Outer Dowsing Offshore Wind (Generating Station) – EN010130

Section 51 advice regarding draft application documents submitted by Total Energies and Corio Generation

On 13 October 2023 Outer Dowsing Offshore Wind submitted the following draft documents for review by the Planning Inspectorate as part of its Pre-application Service¹:

This document may only be used for the purpose for which it was commissioned and in accordance with the terms of engagement for that commission. Unauthorised use of this document in any form whatsoever is prohibited.

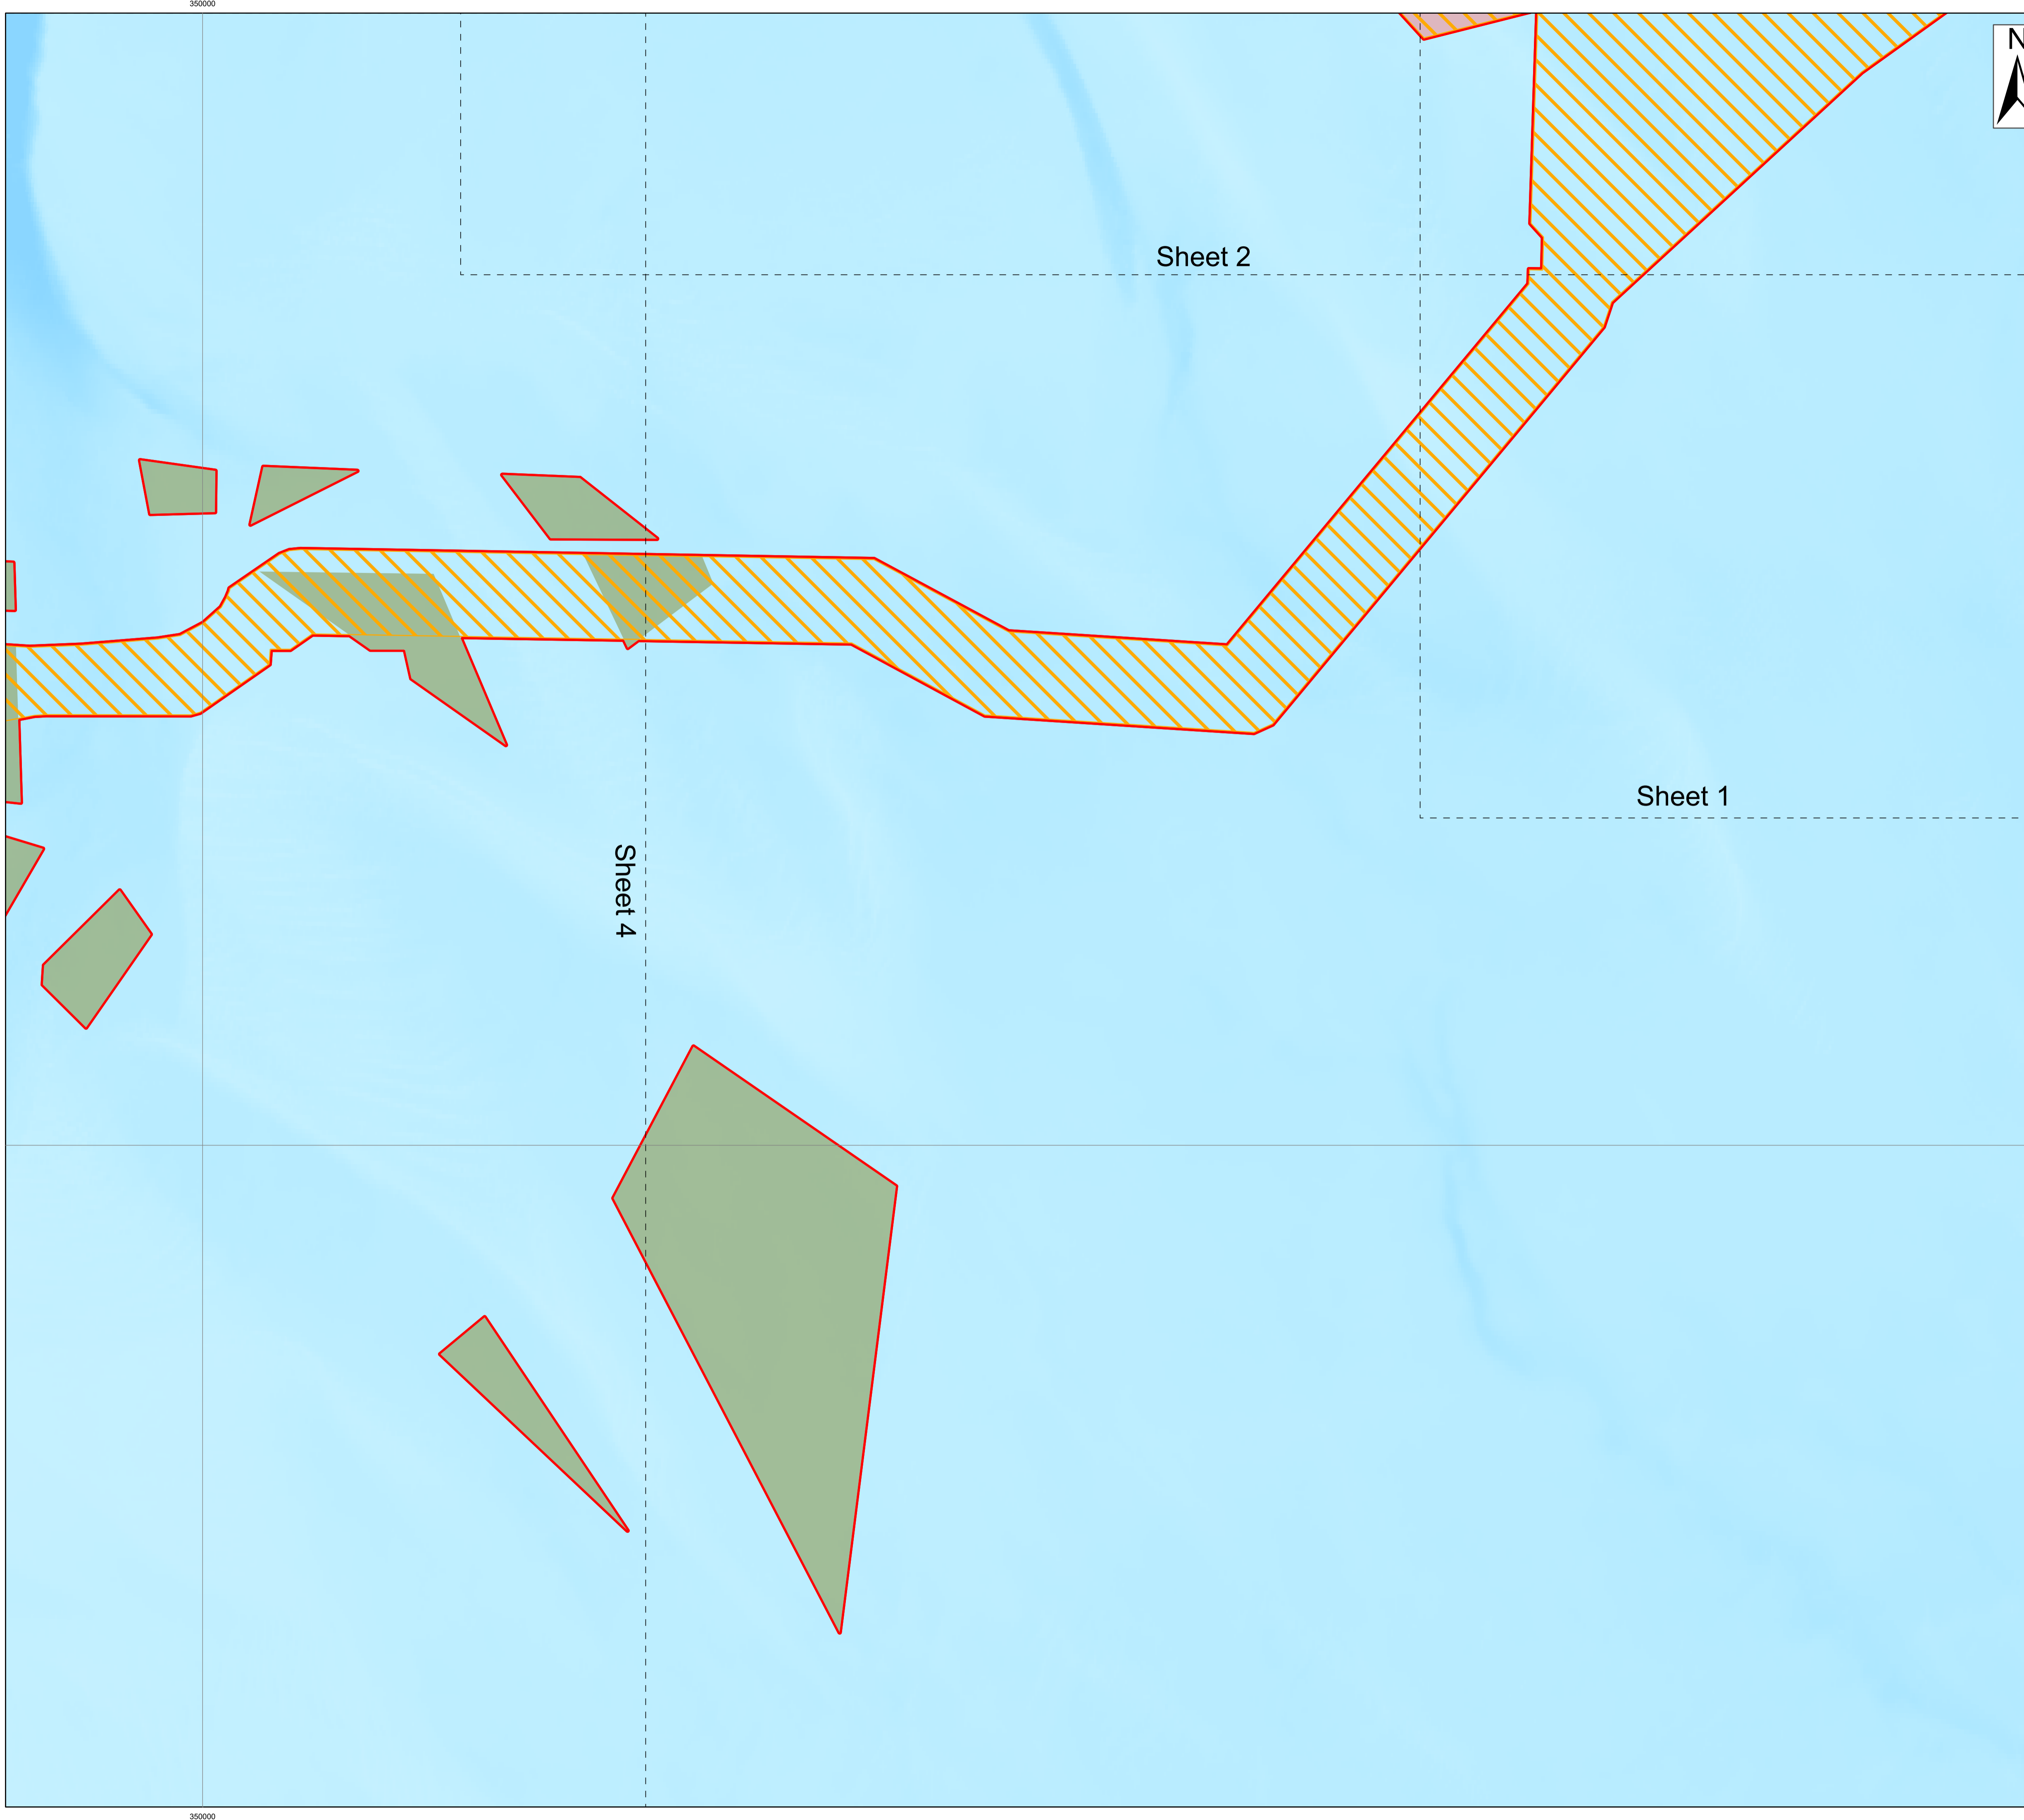
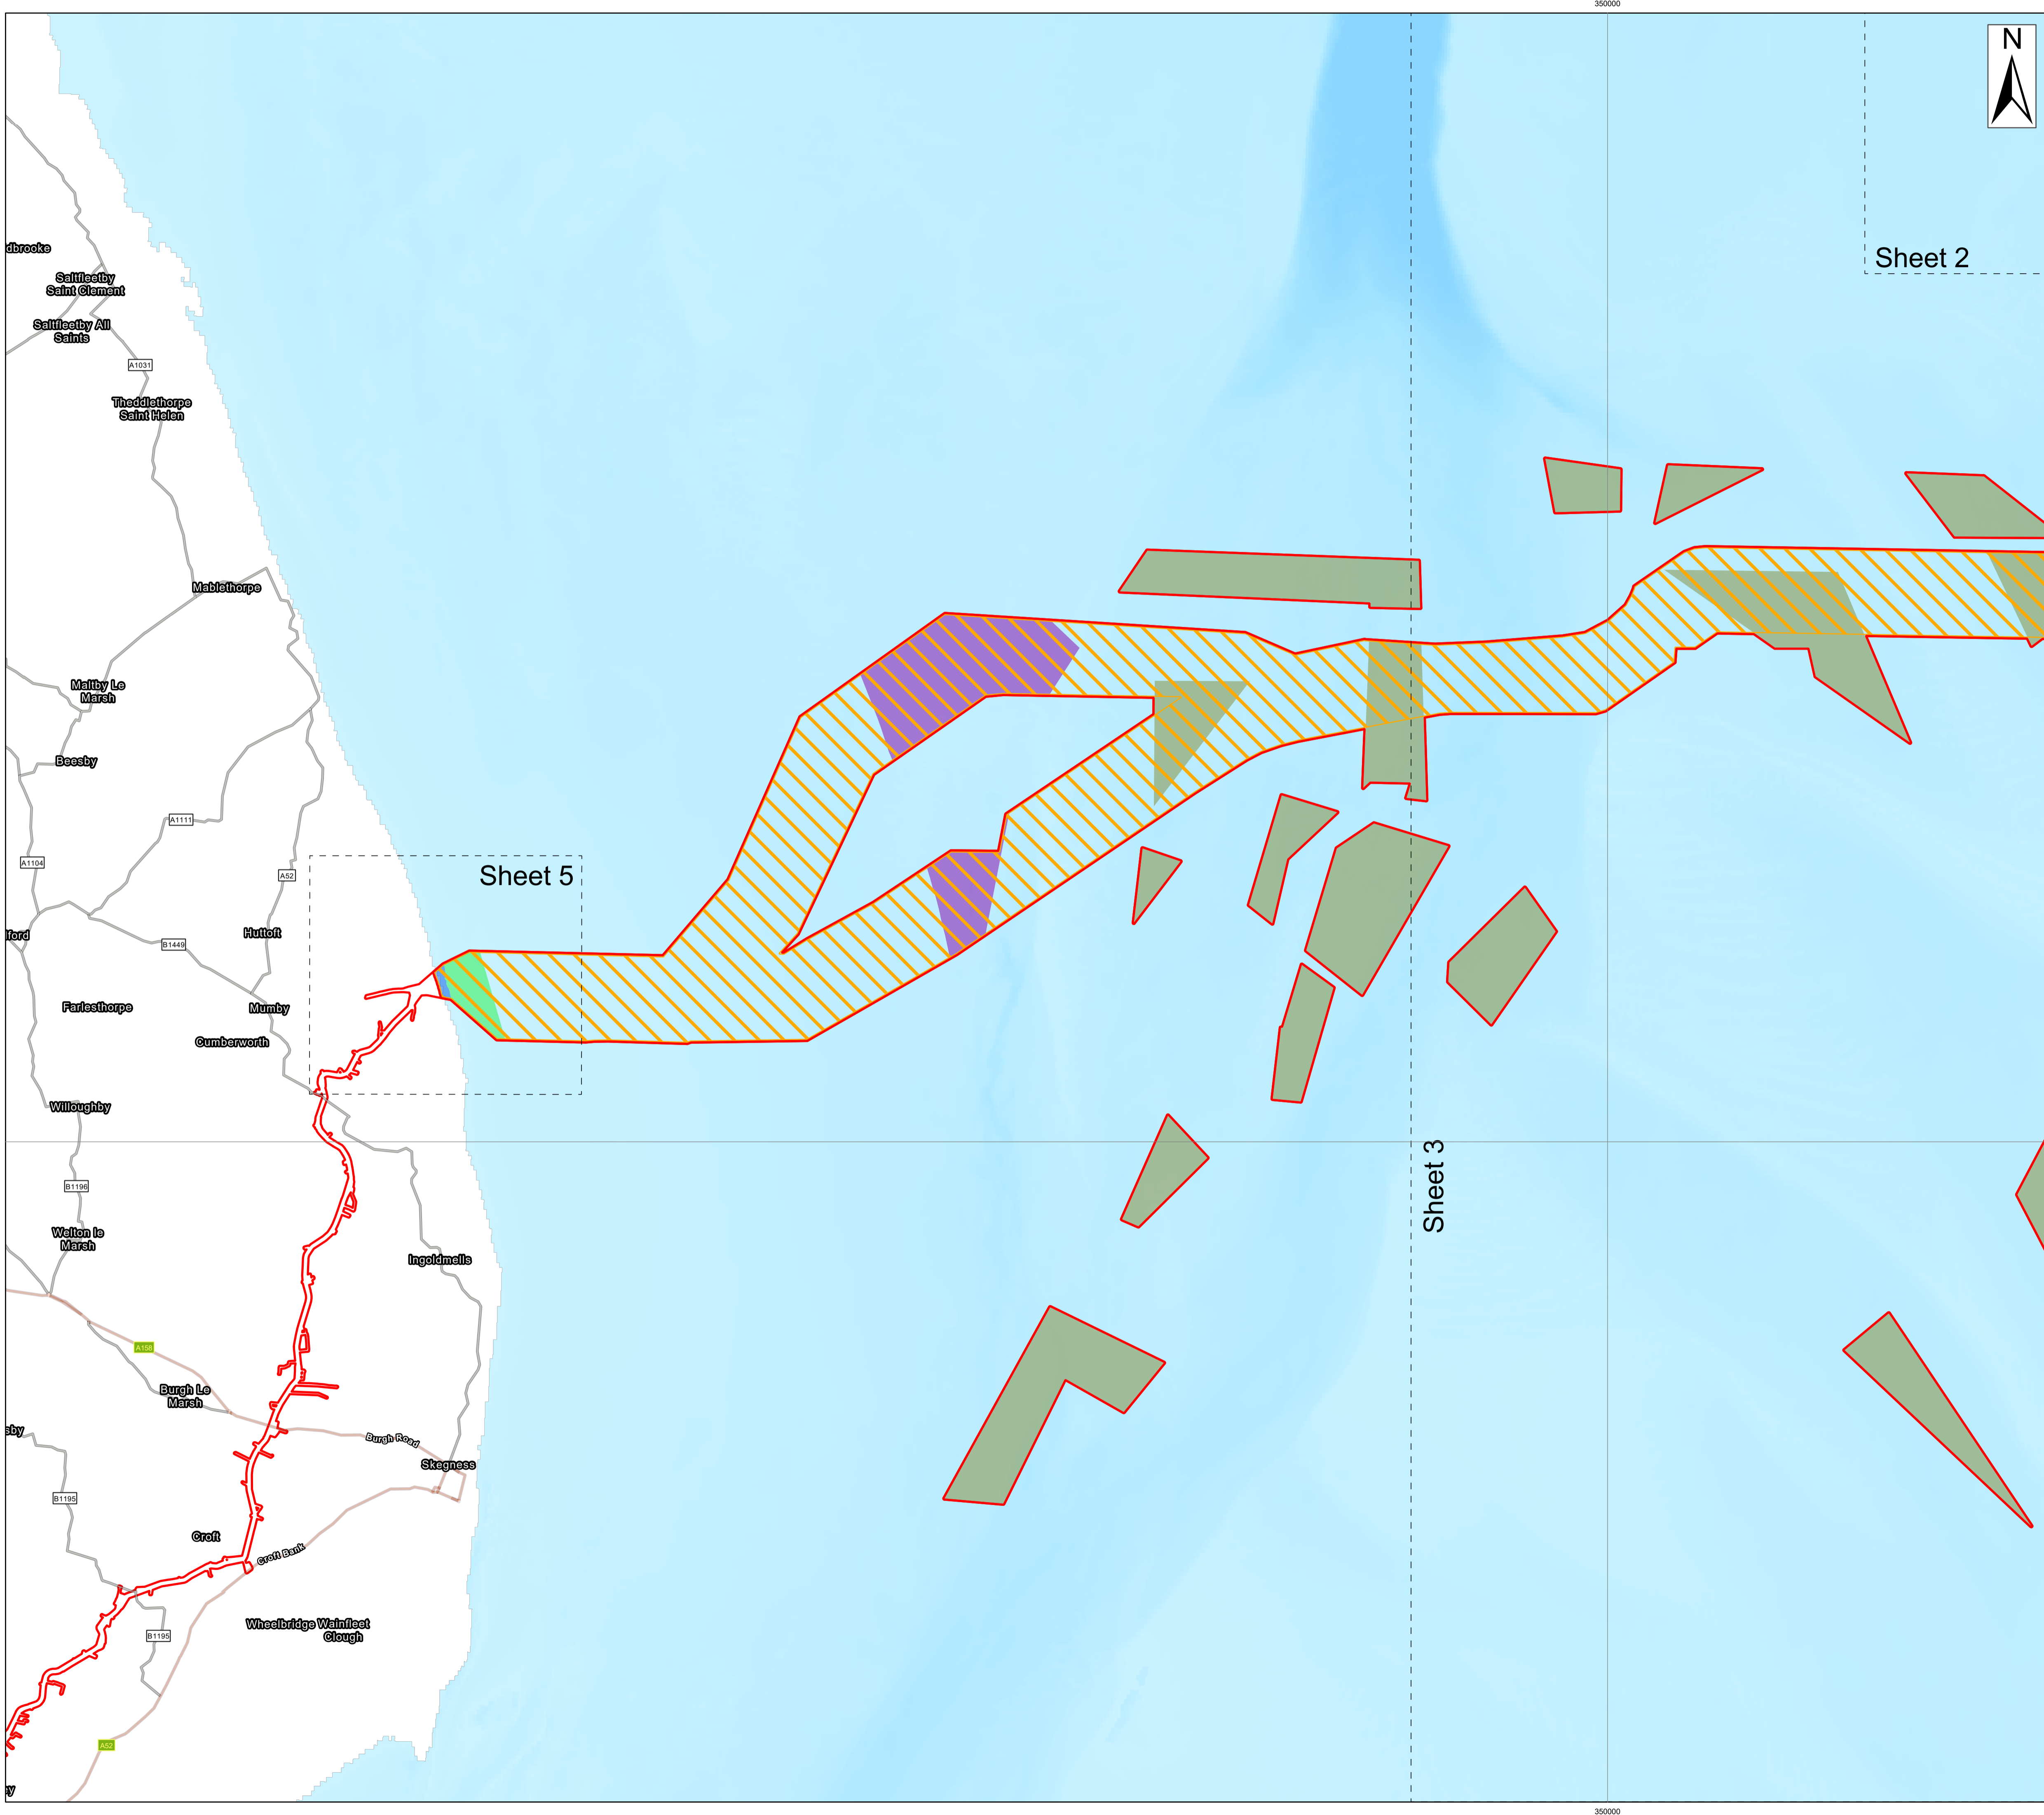
Offshore Works Plans		
Ref No.	Plan ref	Comment/Question
30.	All	Works No. 5 – Offshore export cables and Works No. 8 – Temporary works areas have the same legend colour and pattern. If there are any temporary work areas that include any works other than export cables then they should have a different colour and/or pattern.
31.	Drawing 1 of 5 Drawing 3 of 5	Works No. 10 – Creation and recreation of biogenic reef – This is not included in the Order limit boundary. Is this intentional or an oversight? If intentional, what is the justification for its exclusion?

Drawing: 4 of 5			Page Size: A1		
Rev No:	Date	Description	Drawn	Checked	Approved
1.0	March 2024	DCO Application Version	SR	DM/ODOW	ODOW

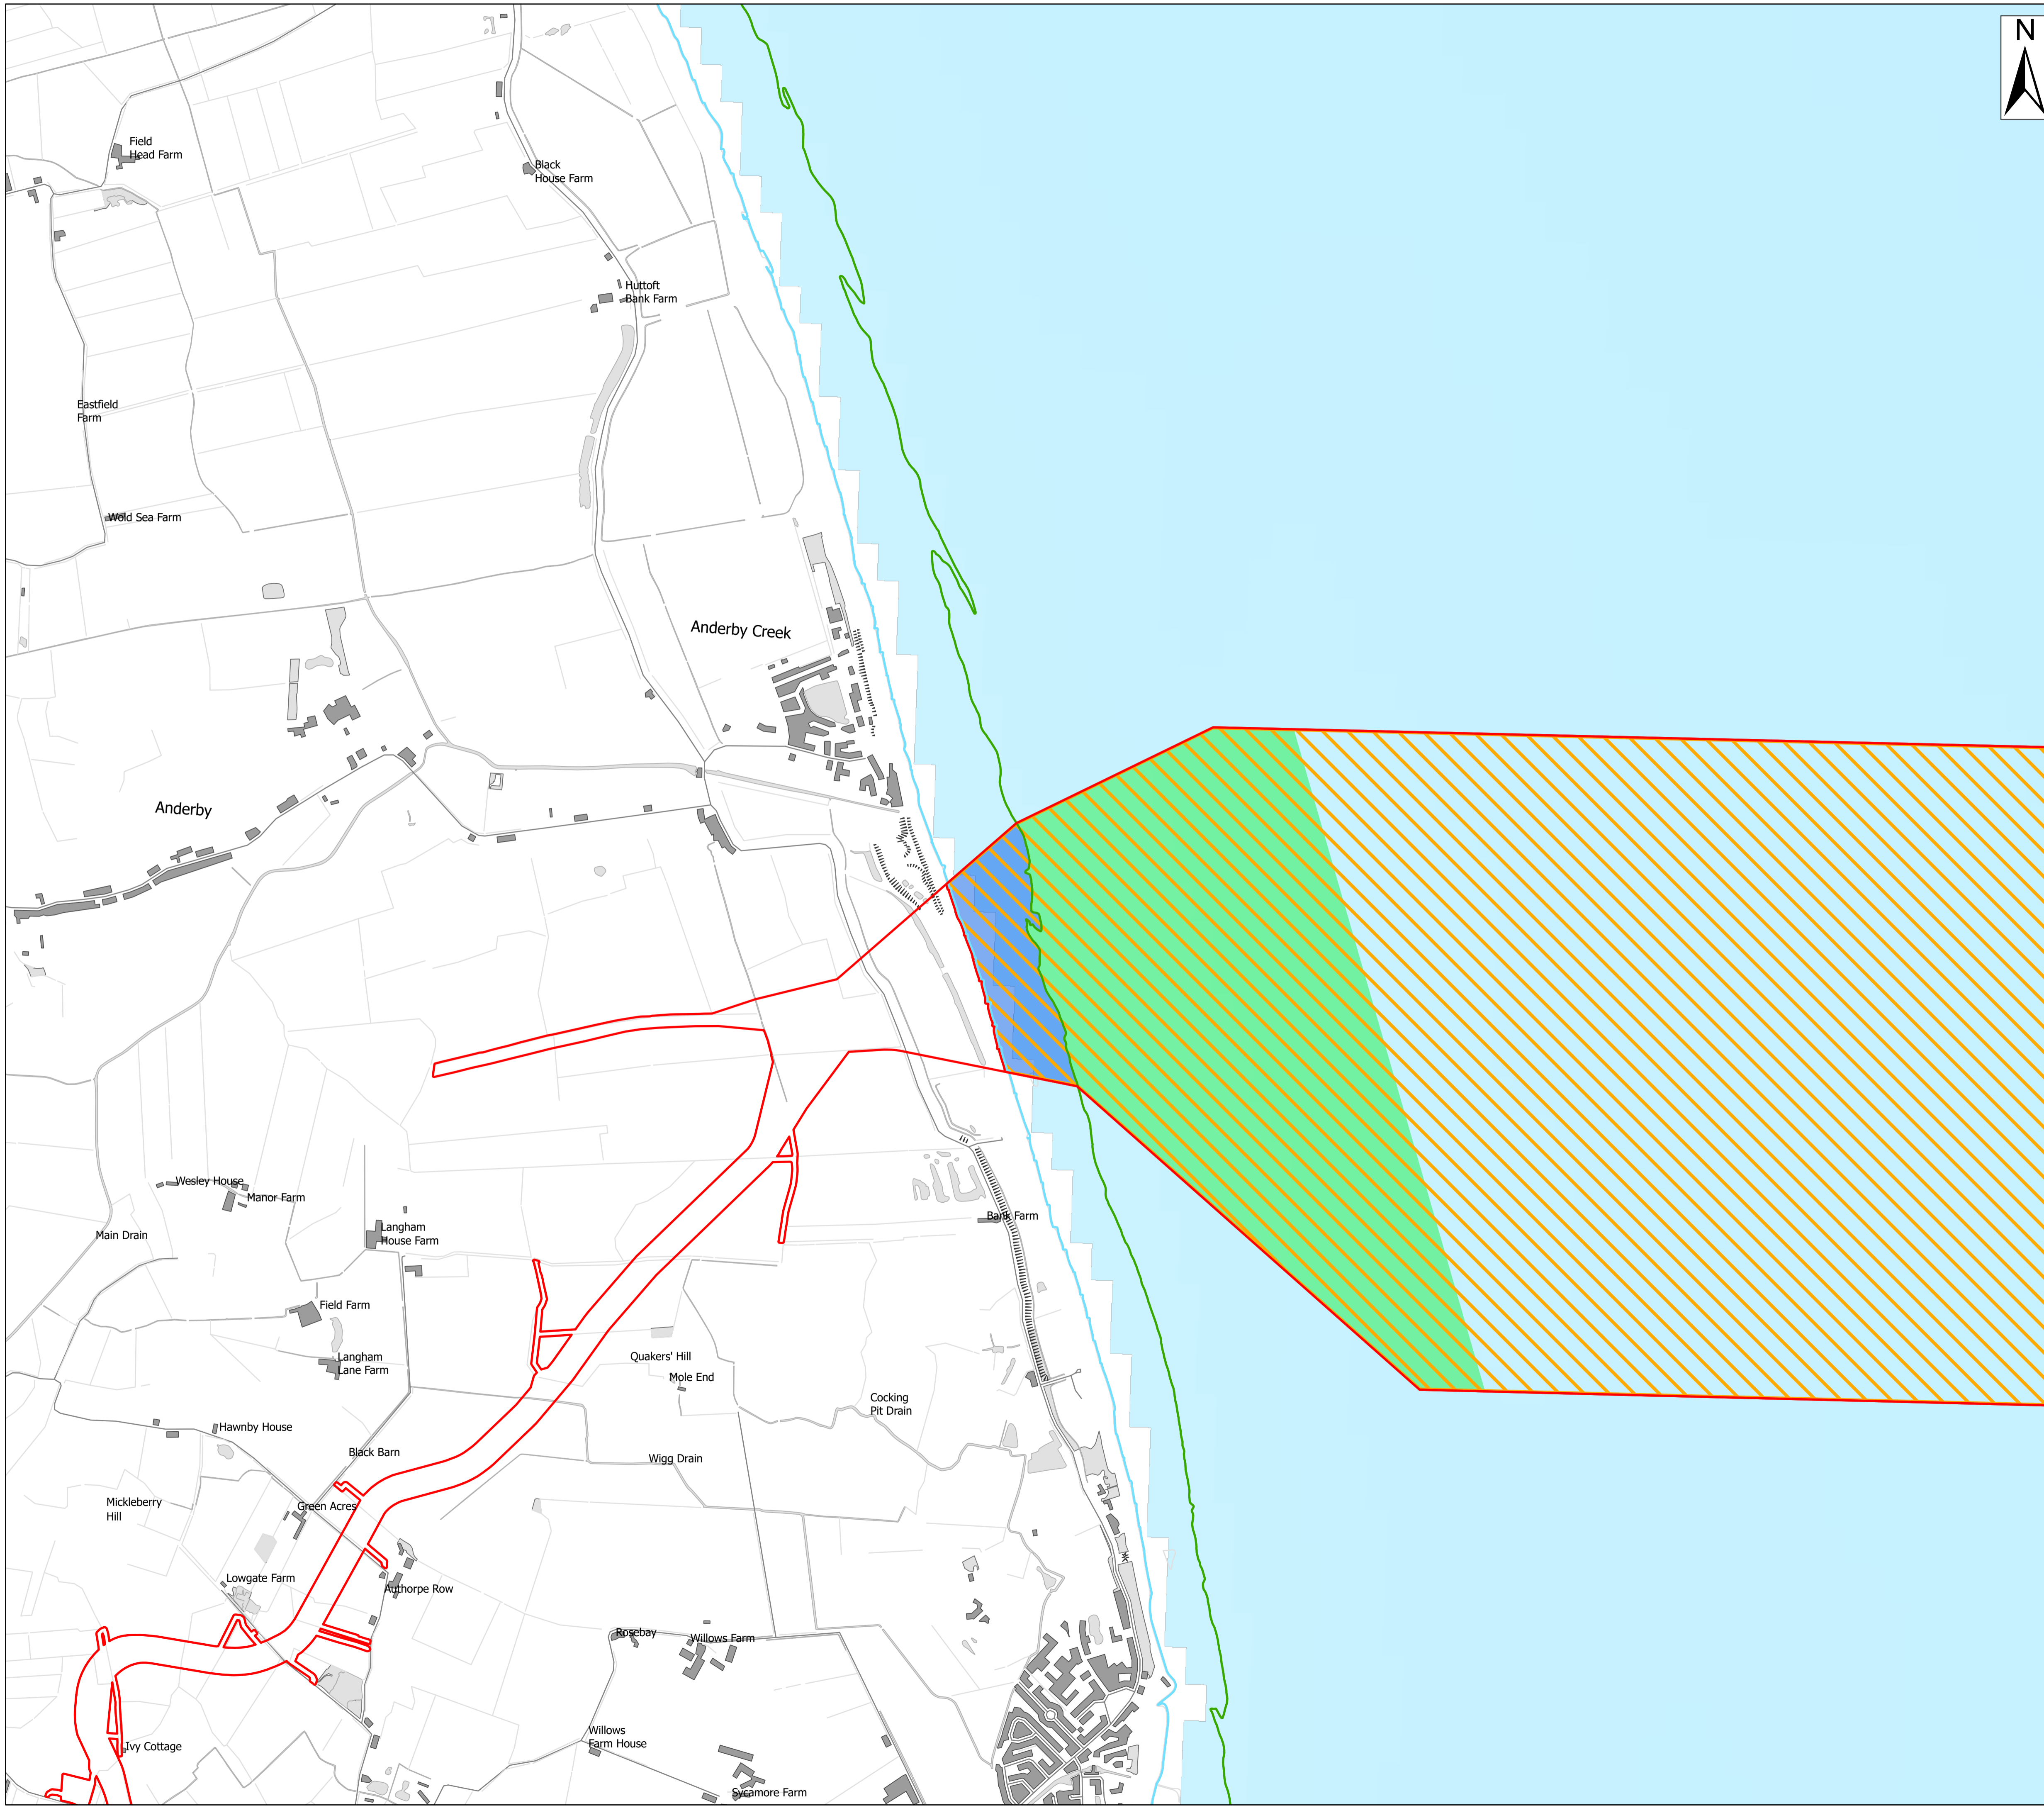
Offshore Works Plans		
Ref No.	Plan ref	Comment/Question
	Drawing 4 of 5
